Kirklees Council
Planning and Development Service
PO Box 1720
Huddersfield
HD1 9EL

Date: 09-May-2024
Our Ref: 2023/93464

**Discharge of conditions 4 (Phase II report), 5 (Remediation Strategy), 8 (Construction Environmental Management Plan), 9 (CEMP: Biodiversity), 10 (road condition survey), 11 (estate roads), 12 (Lingards Road footway), 13 (highway retaining walls), 14 (highway embankments), 15 (Stability Remediation Strategy), 16 (drainage infrastructure in highway), 17 (drainage scheme), 18 (flood routing), 19 (temporary drainage), 20 (Arboricultural Method Statement), 21 (bridge details), 22 (green retaining wall), 23 (Ecological Design Strategy), 24 (ecological measures), 25 (materials), 26 (footpath connections), 27 (landscaping), 28 (lighting), 29 (temporary waste arrangements), 30 (pedestrian improvements), 31 (pedestrian improvements) and 33 (cycle parking) of previous permission 2020/93954 for erection of 42 dwellings and associated works
Land at, Lingards Road, Slaithwaite, Huddersfield, HD7 5HY
Application Number: 2023/93464**

SB HOMES
LINGARDS ROAD
FOOTPATH DETAILS
DRG SK S05

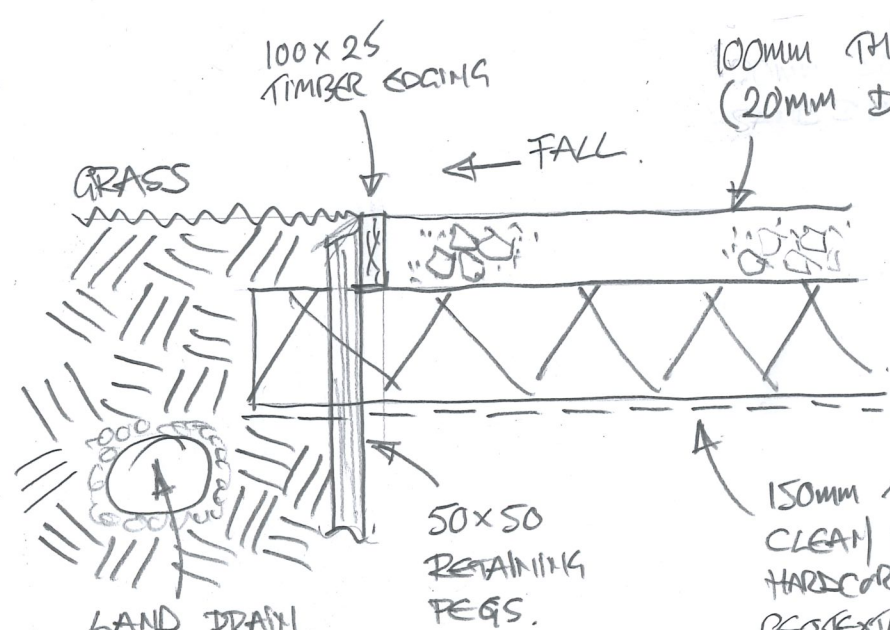
You have submitted the plan ref: Sk S 05 f pursuant to condition 26. The submitted details are not acceptable, for the following reasons:

- The condition requires details of all paths identified as ‘footpath link’s’ on plan ref: E19/7567/000 rev N. The plan submitted with this application includes a similar plan to E19/7567/000 rev N, but then highlights only two smaller link paths and gives specific details on them. There is a general path section, but it is unclear if that relates solely to the highlighted section or all elements.

- Further to this uncertainty, there are various concerns with the general path section:
 - A 100mm sandstone surface is proposed. Given the varied topography of the site concerns are held over this, although limited levels of the paths have been provided to confirm. Rainfall or general usage will result in this surface falling downhill, resulting in its steady removal from the path or constant maintenance burden. Confirmation of levels across all paths should be provided and, if notably steep, consideration given to whether sandstone is appropriate or if other materials should be used.

- No details of the grade of the hardcore are provided.
 - No details of the proposed stairs are provided. On the submitted plans the connection to PROW COL/133/10 is shown as a ramp, yet other plans show it as stairs. The plans should be updated to be consistent. Details of stairs including their steepness, use of handrails, size and treatment throughout the site, should be provided.

- Specific details of land drain locations should be provided. There are concerns over the indicative details and whether the drains would conflict with features such as proposed trees or domestic curtilages.

THE ROOT PROTECTION AREAS OF T3 AND T4 HAVE BEEN OFF-SET IN ORDER TO TAKE INTO CONSIDERATION THAT THEY ARE GROWING IN AN ELEVATED LOCATION ON A RAISED STONE FEATURE

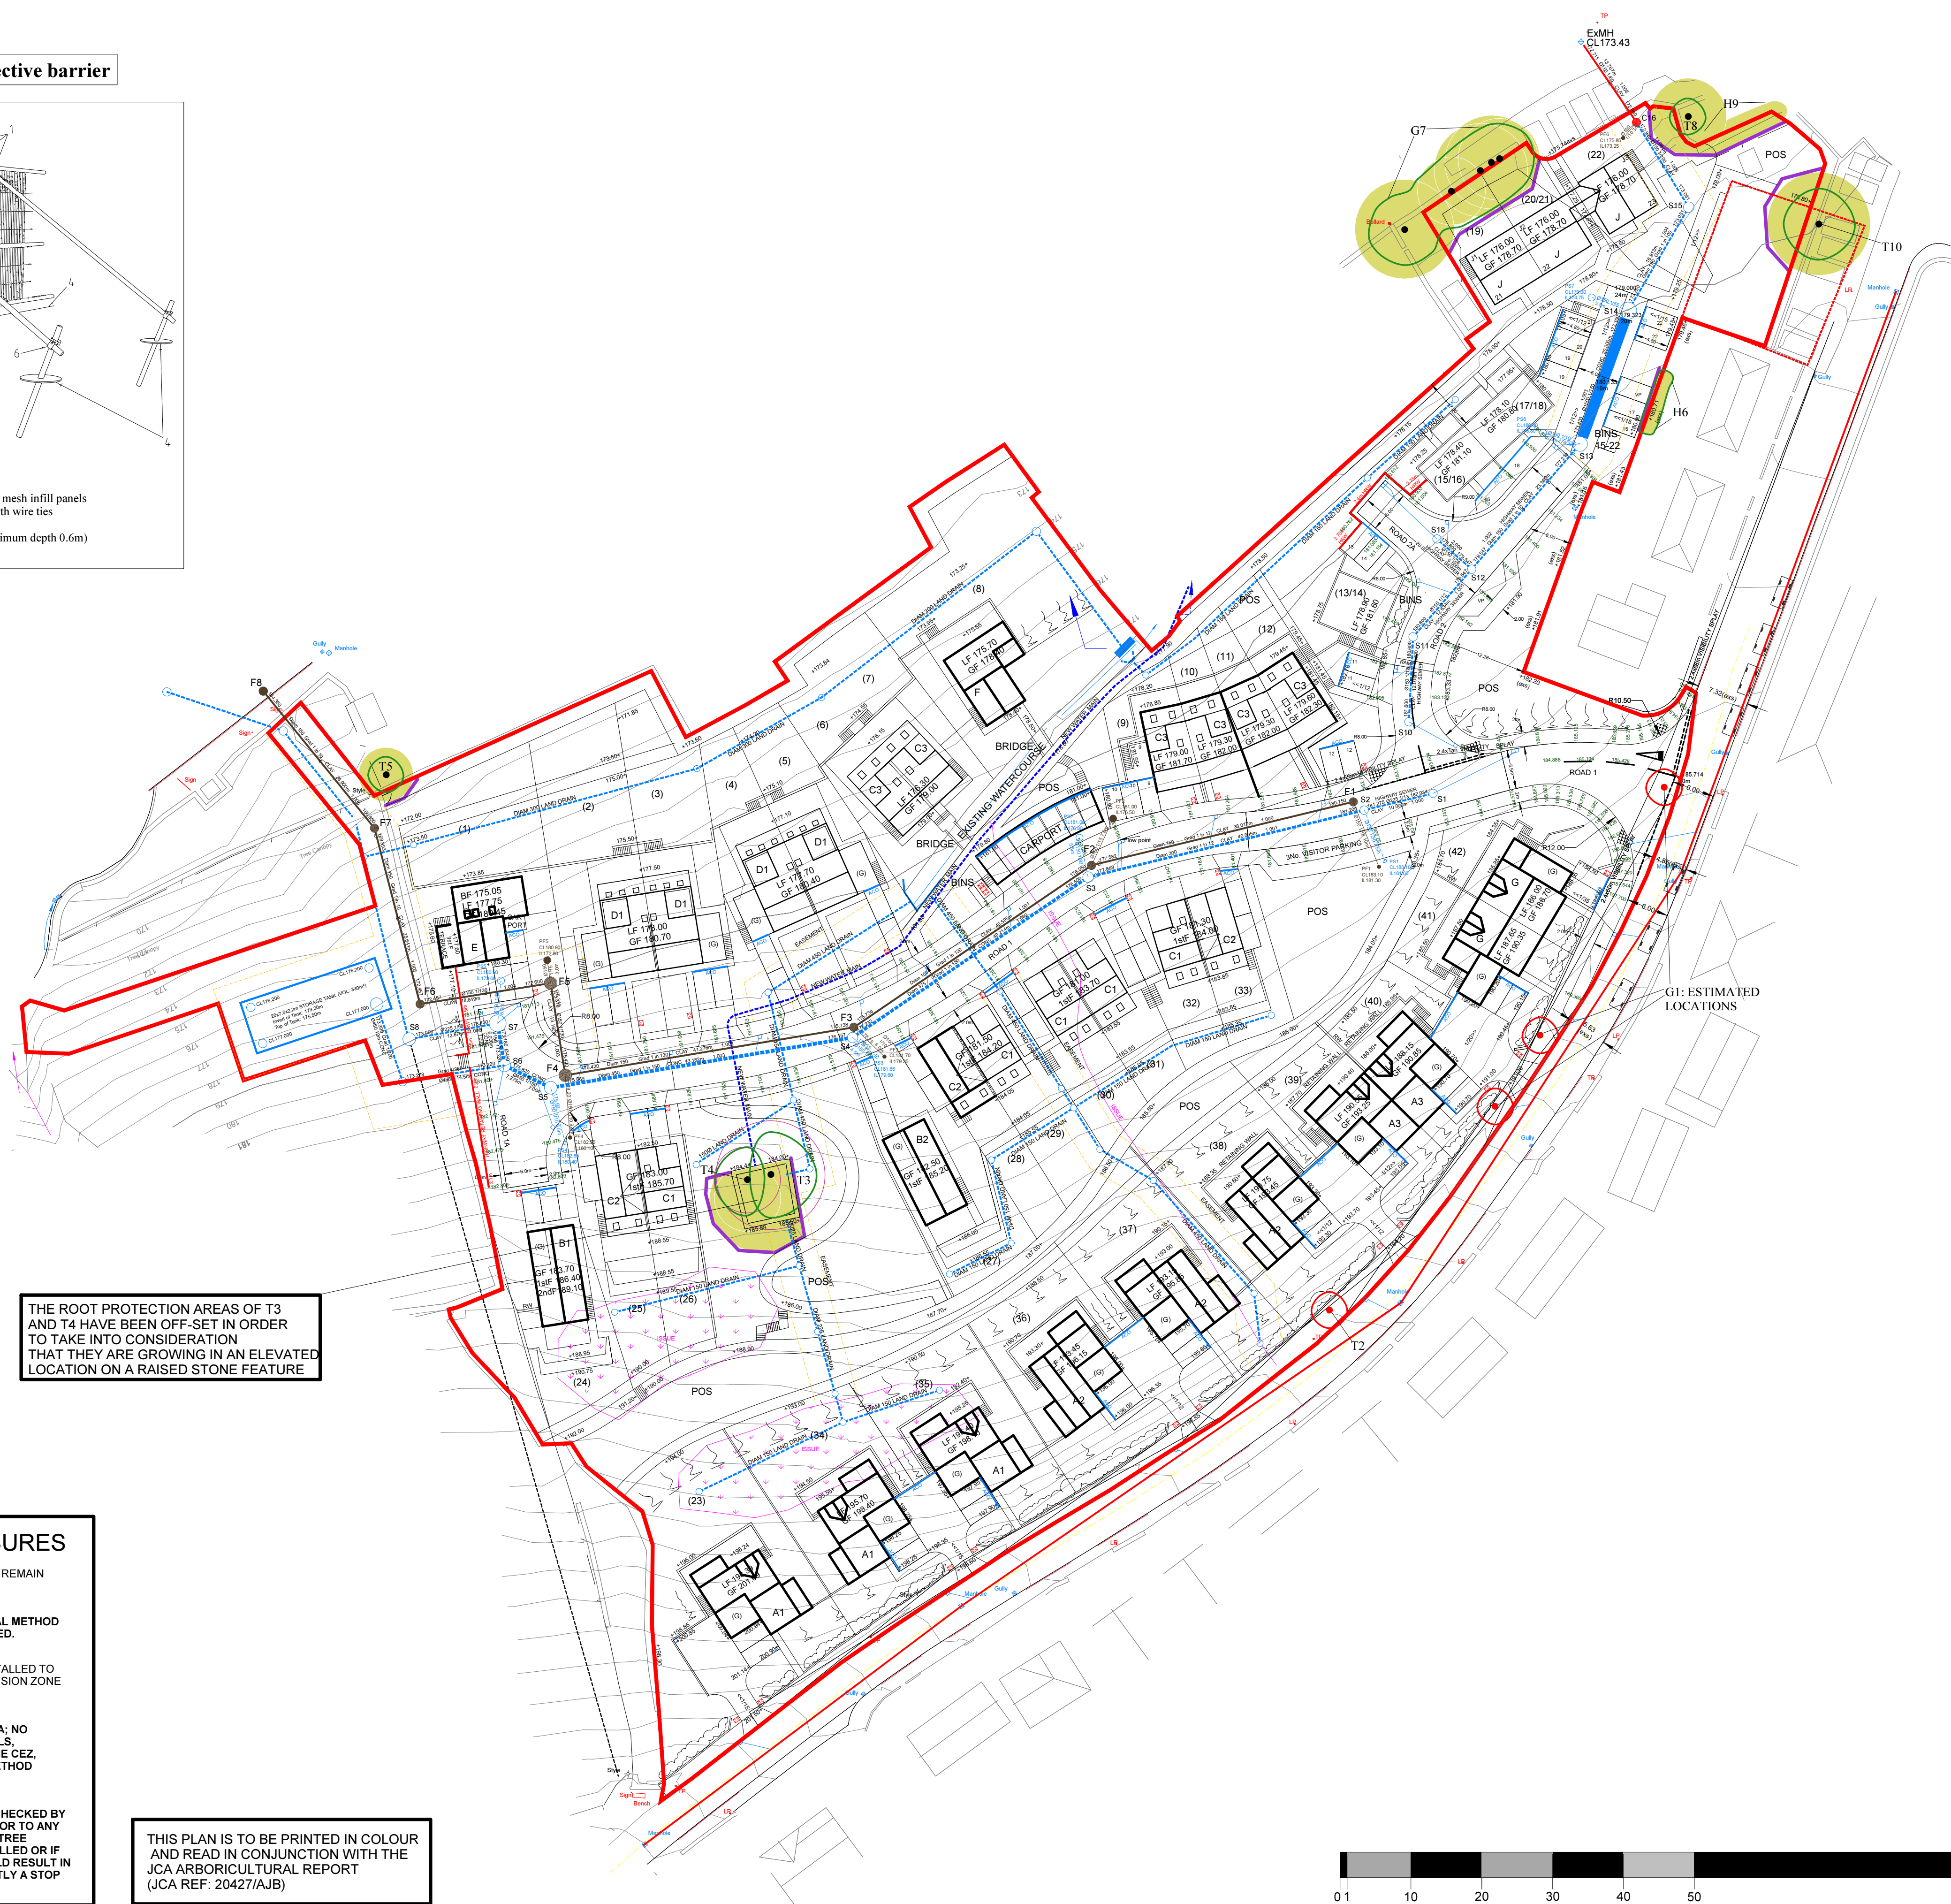
- The proposed protection fencing around T3 and T4 isn't acceptable. There is a requirement to protect the overhanging canopies of trees where they could be damaged by machinery, vehicles, barriers or scaffolding, where it will be necessary to increase the extent of the tree protection barriers to contain the canopy (BS5837:2012 5.2.3.e). It is likely the canopies of T3 and T4 will be vulnerable to damage by machinery and vehicles to a point that their canopy spread should be encompassed with default specification tree protection fencing as shown in Appendix 2: Protective Barrier of the AMS.

- Considering the trees T3 and T4 are within a POS and the value of T3, it would be good to protect the nominal RPA of the trees with fencing as shown in Appendix 2: Protective Barrier of the AMS and then treat it as sacrosanct.

- Section 4.3 of the AMS is not correct. New hard surfaces are proposed within the RPA of T10 based on the TPP plan.
- Lastly, conditions 16 (drainage infrastructure in highway), 17 (drainage scheme) and 19 (temporary drainage) are being discharged too as part of this application. Since details on service routes are not available at the time the AMS was written the AMS needs amendments. It would be good for these details to be provided to the project arboriculturist so they can be included for consideration within the revisions.
